SEPA Environmental Checklist
Mercer Island Center for the Arts

Attachment R
Citizen Question Index

MICA SEPA PUBLIC QUESTION/COMMENT INDEX

MERCER ISLAND CENTER FOR THE ARTS CONCEPTUAL MITIGATION PLAN

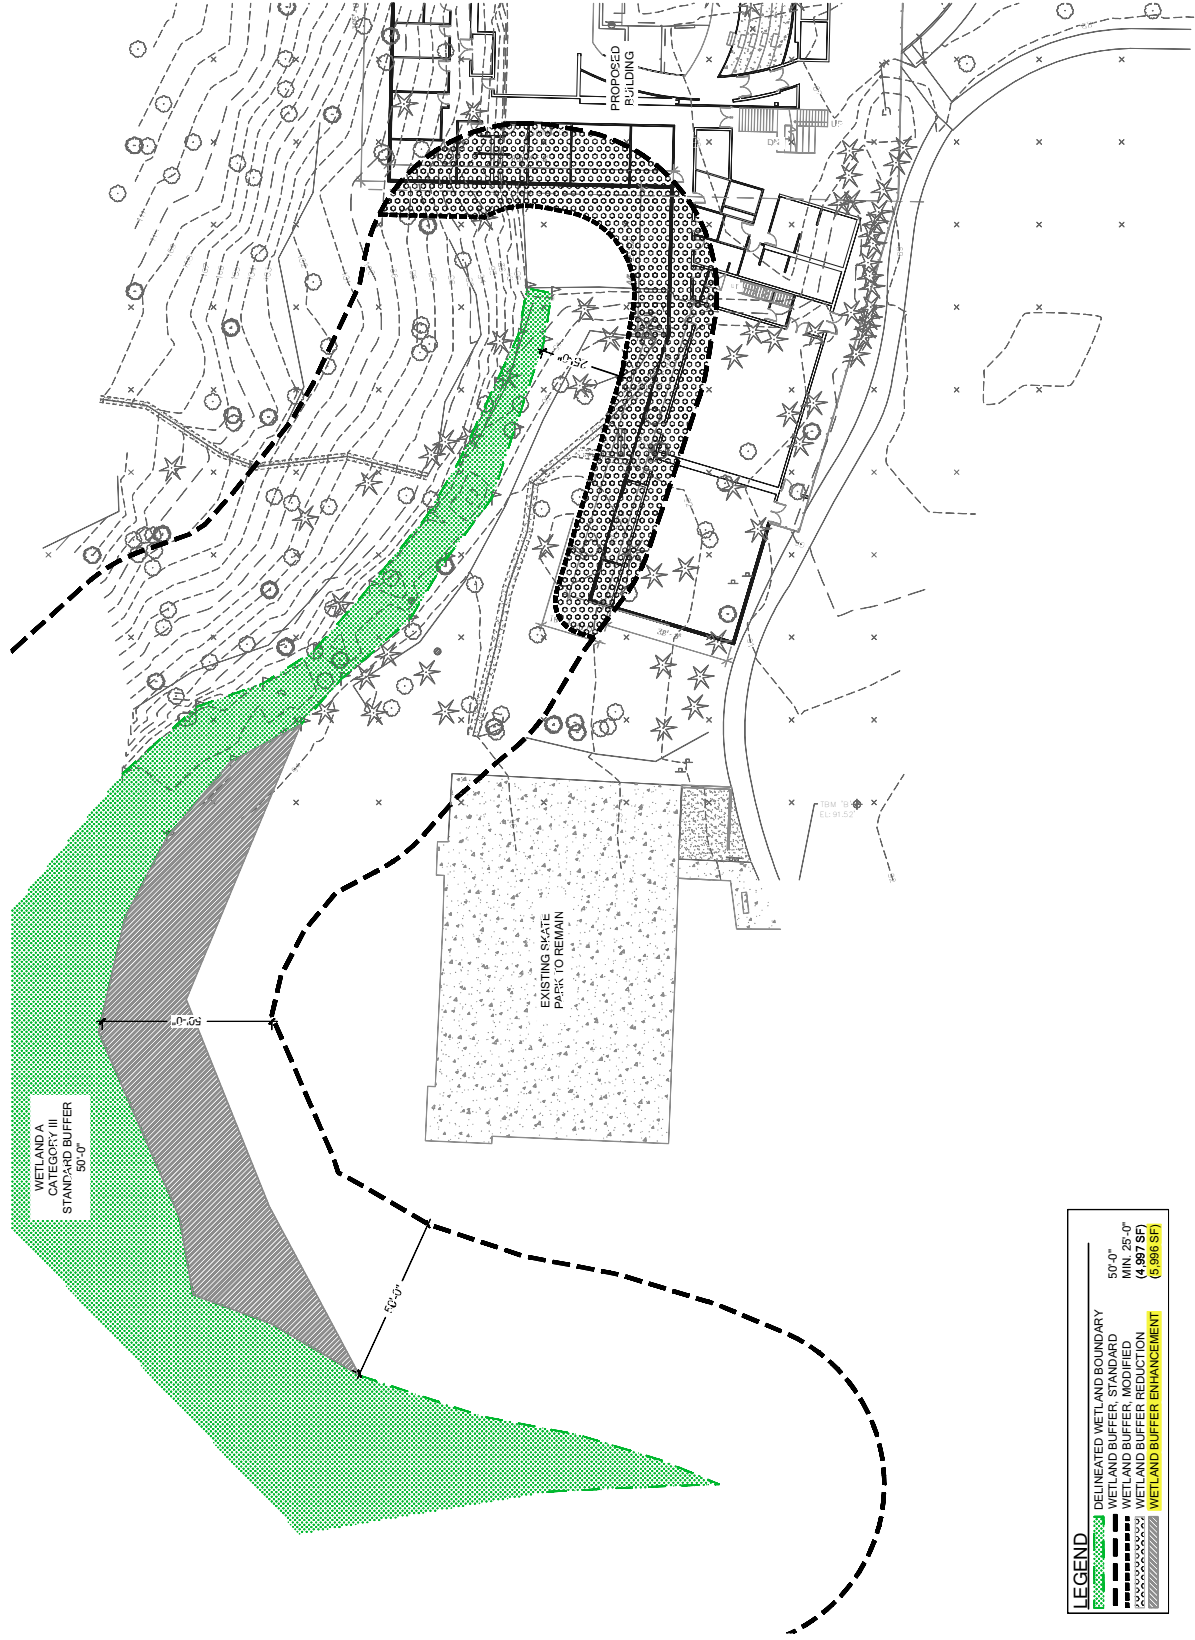
B.3.1	96	Lippert, Meg	When and by what authority was the buffer changed from 50 feet to 25 feet? "Wetland mitigation" is mentioned, but no mitigation is described. What is the mitigation, and who will be responsible for approving and supervising it?
B.3.1	125	Kuttner	The wetlands in the vicinity of the Town Center should be rehabilitated, not paved over.
B.3.2	97	Lippert, Meg	Where is the bio-retention area and how will runoff water be treated?
B.3.2	112	Thompson	MICA will significantly affect the surface water and runoff from the hill behind it, and will negatively affect the animals and plants in the wetland
B.3.3	62	Granbois	The SEPA Checklist § B, Q. 1 subsection g is non responsive. The specific percentage of impervious surface coverage was not noted.
B.3.3	95	Lippert, Meg	What is the percent of impervious surface?
B.4	28	Fletcher	If MICA installs a retaining wall will that mean the destruction of more trees?

SHEET NAME
SITE AND PAVING PLAN

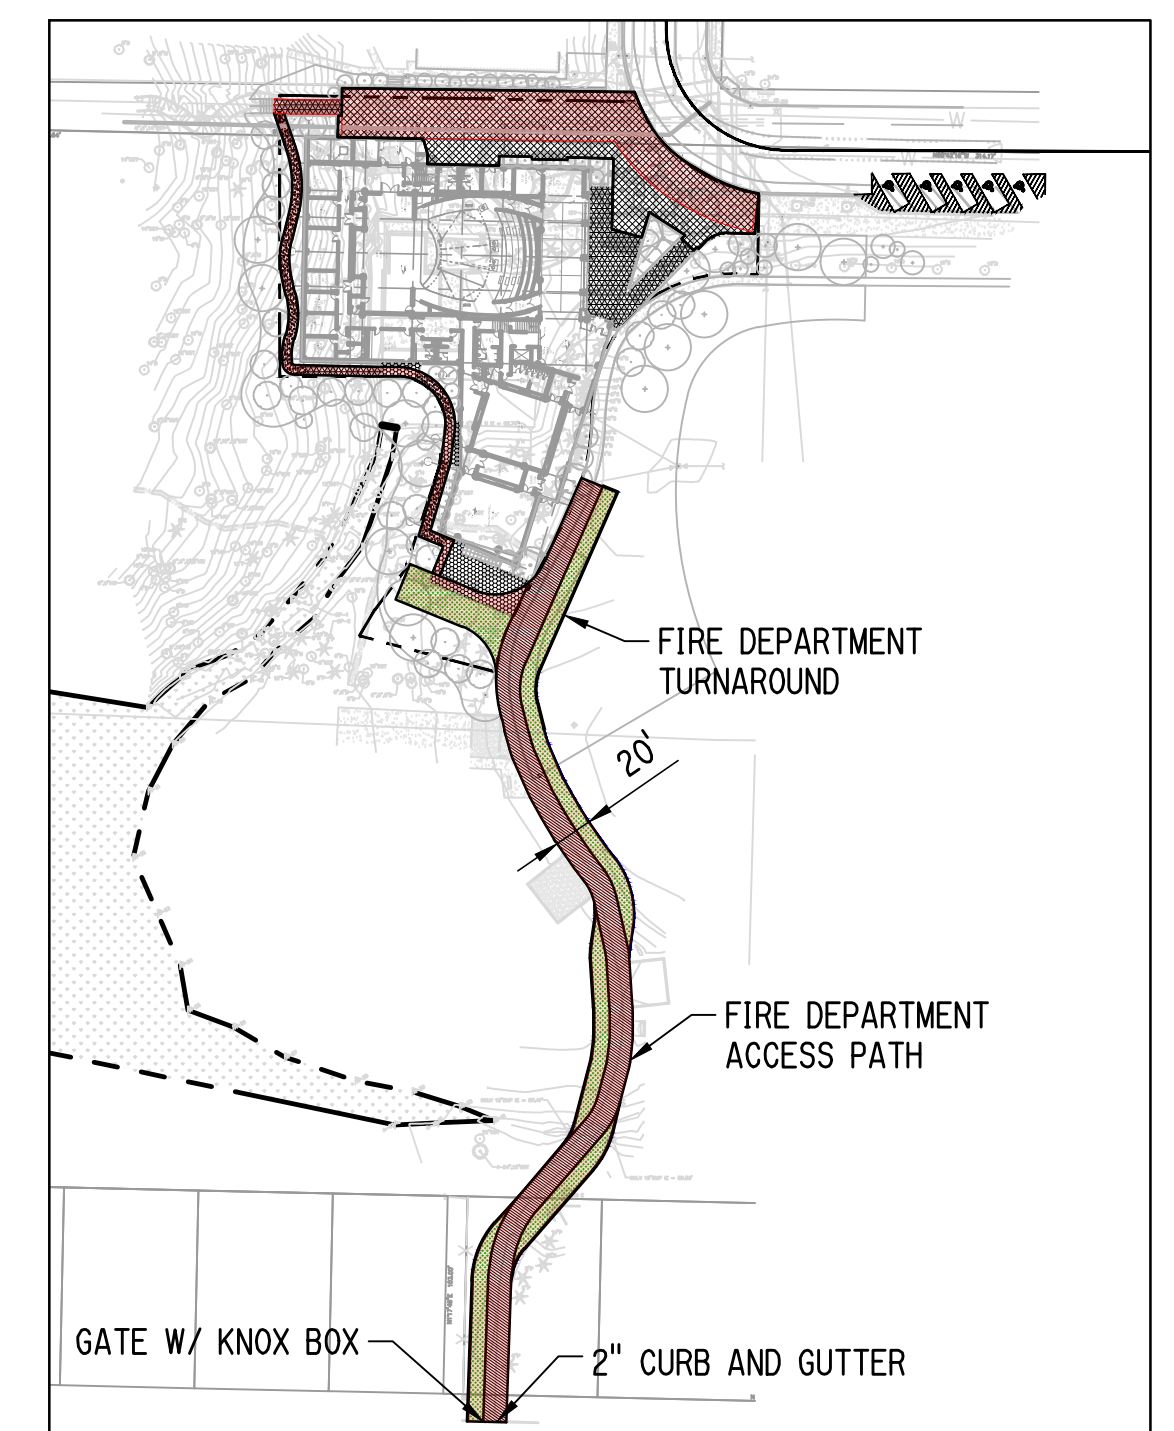
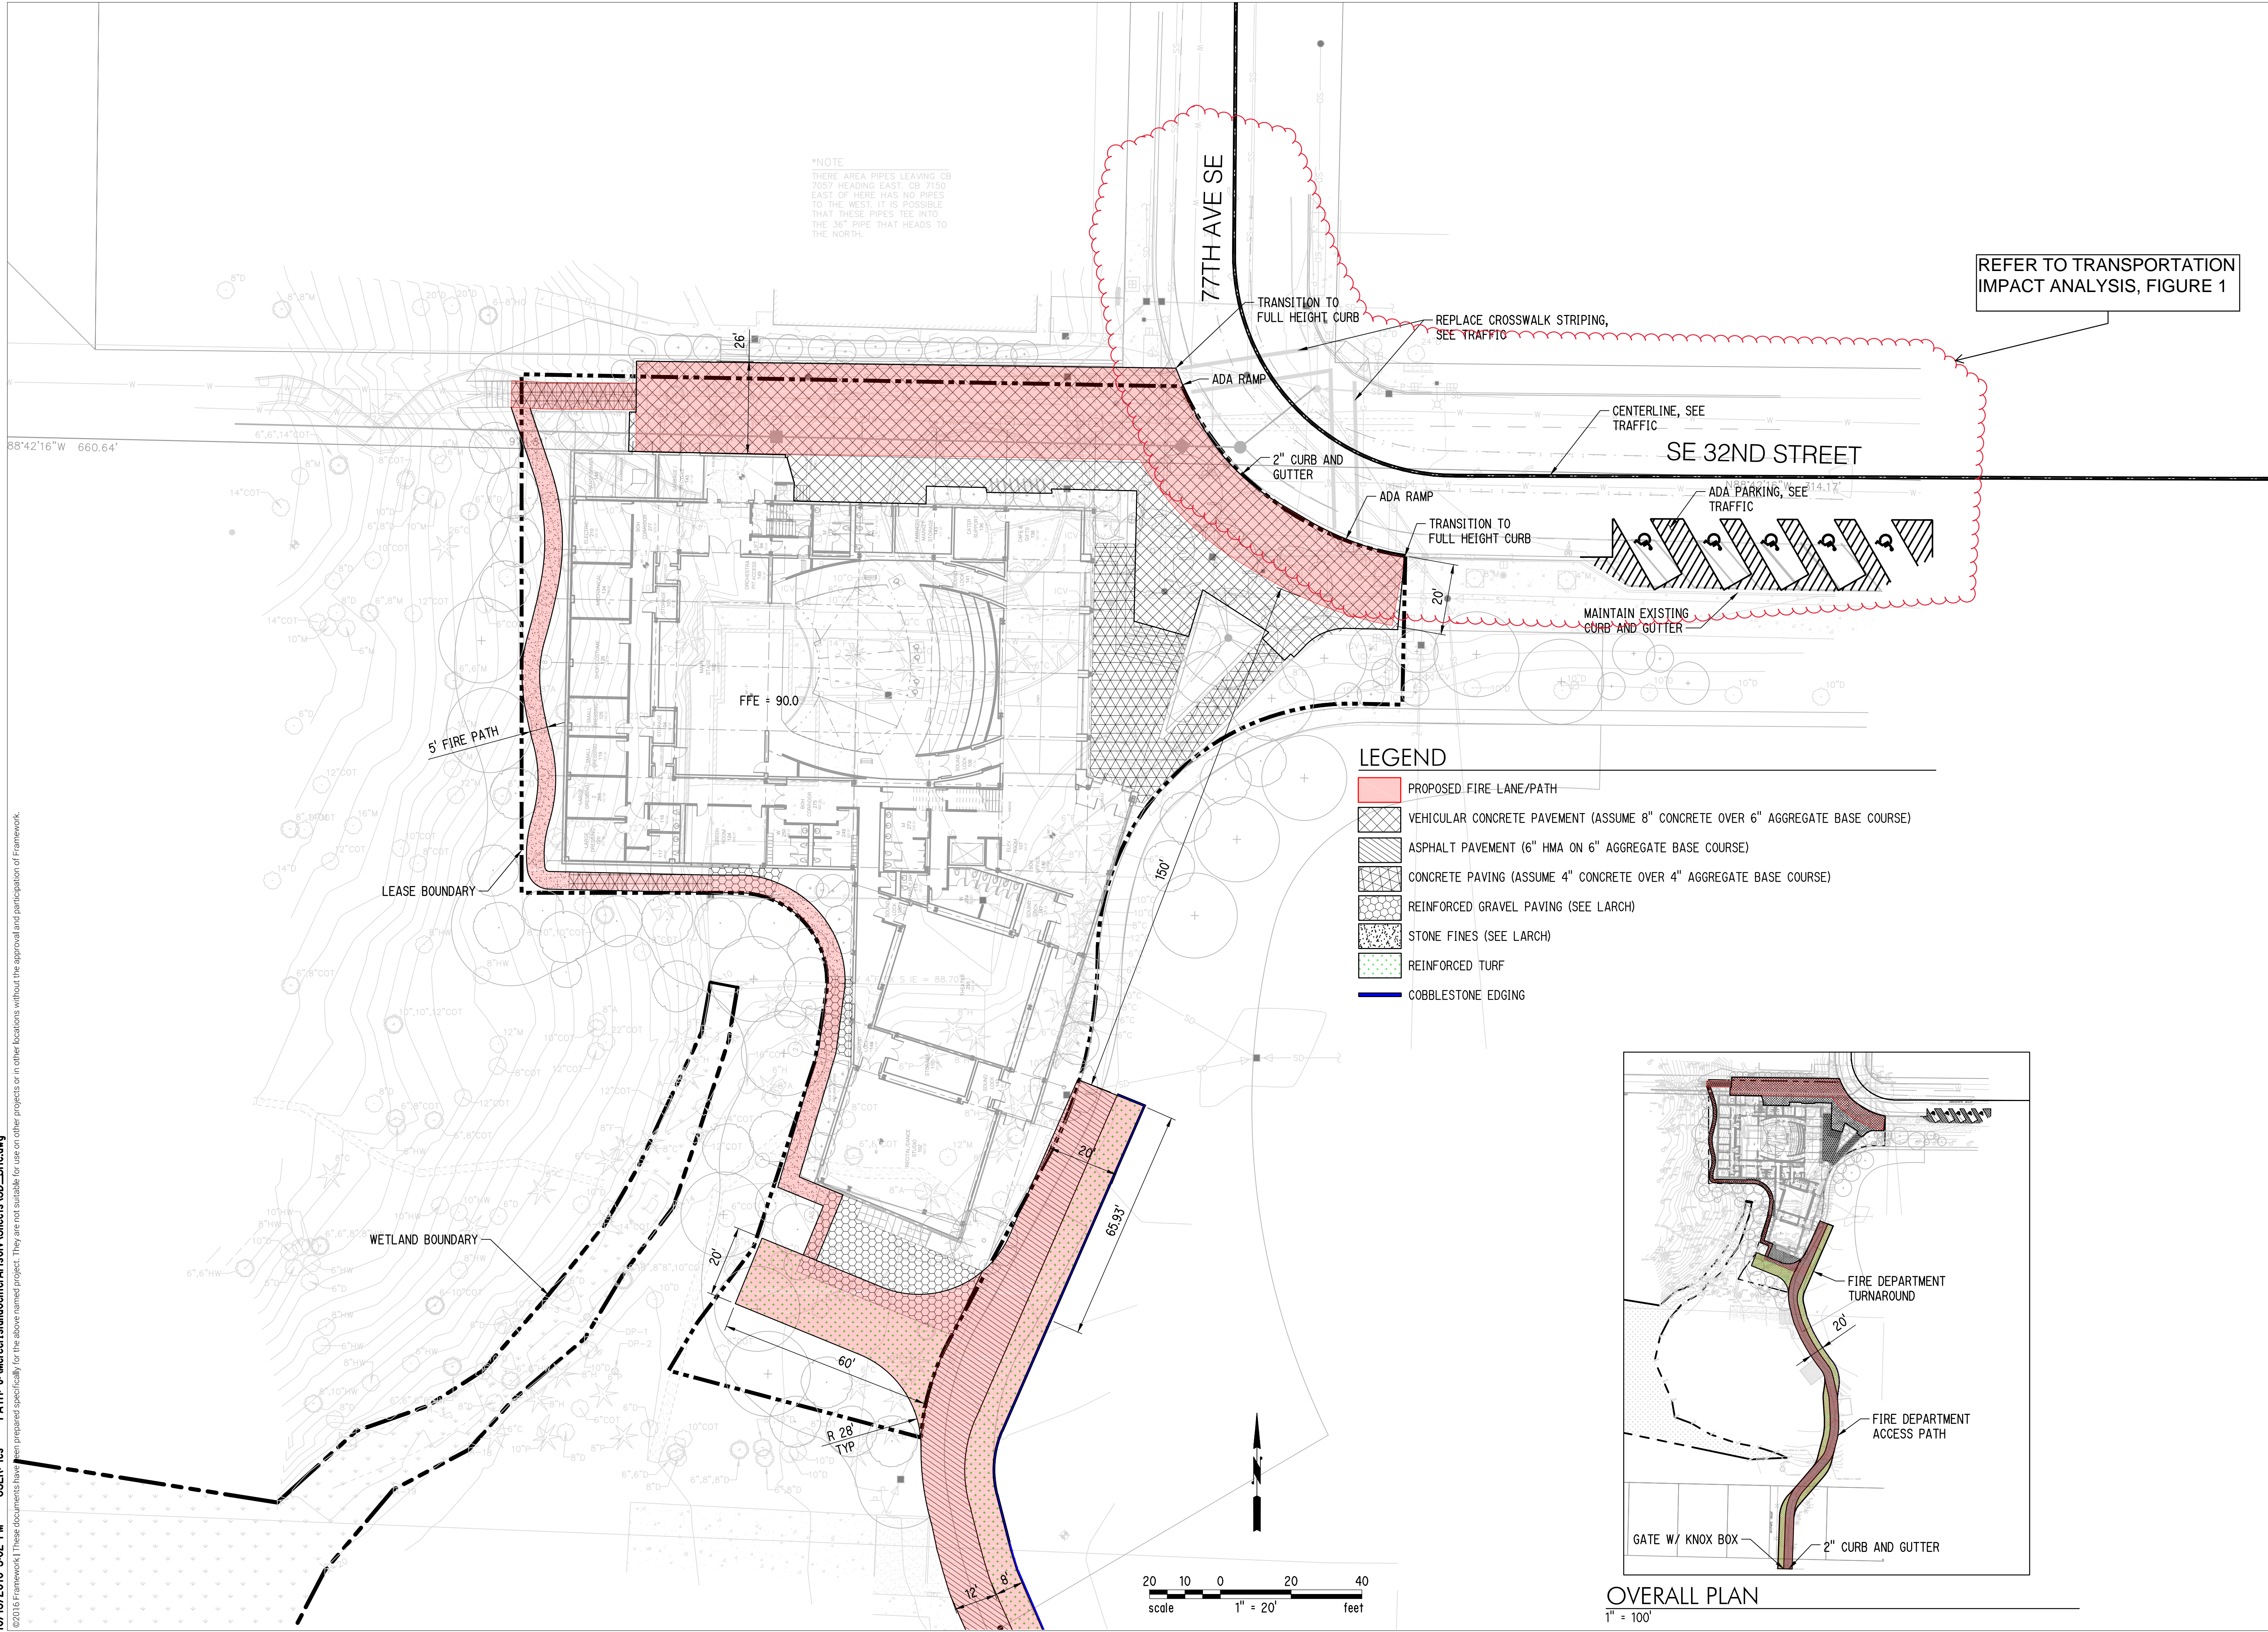
B.4	98	Lippert, Meg	B.4.a Plants--"grass" and "other types of plants" should have been checked. Some grass will be covered by pavement according to the site plans, and "other types of vegetation" include pink and white cyclamen and other woodland plants.
B.4	99	Lippert, Meg	4.b.The comment "The vegetation...is not generally healthy" is a judgement call. Most of the trees and vegetation that would be removed are thriving. It is a lovely woodland environment treasured by the community and providing habitat for native birds and animals. The area is in use and contains trails built and maintained by the City, as well as two benches where citizens can relax and enjoy the surrounding woods.
B.4	101	Thompson	I object to and disagree with MICA's mitigation plan for the loss of wetlands and the effect it will have on flora and fauna.
B.5	116	Thompson	MICA will negatively affect the animals and plants in the wetland
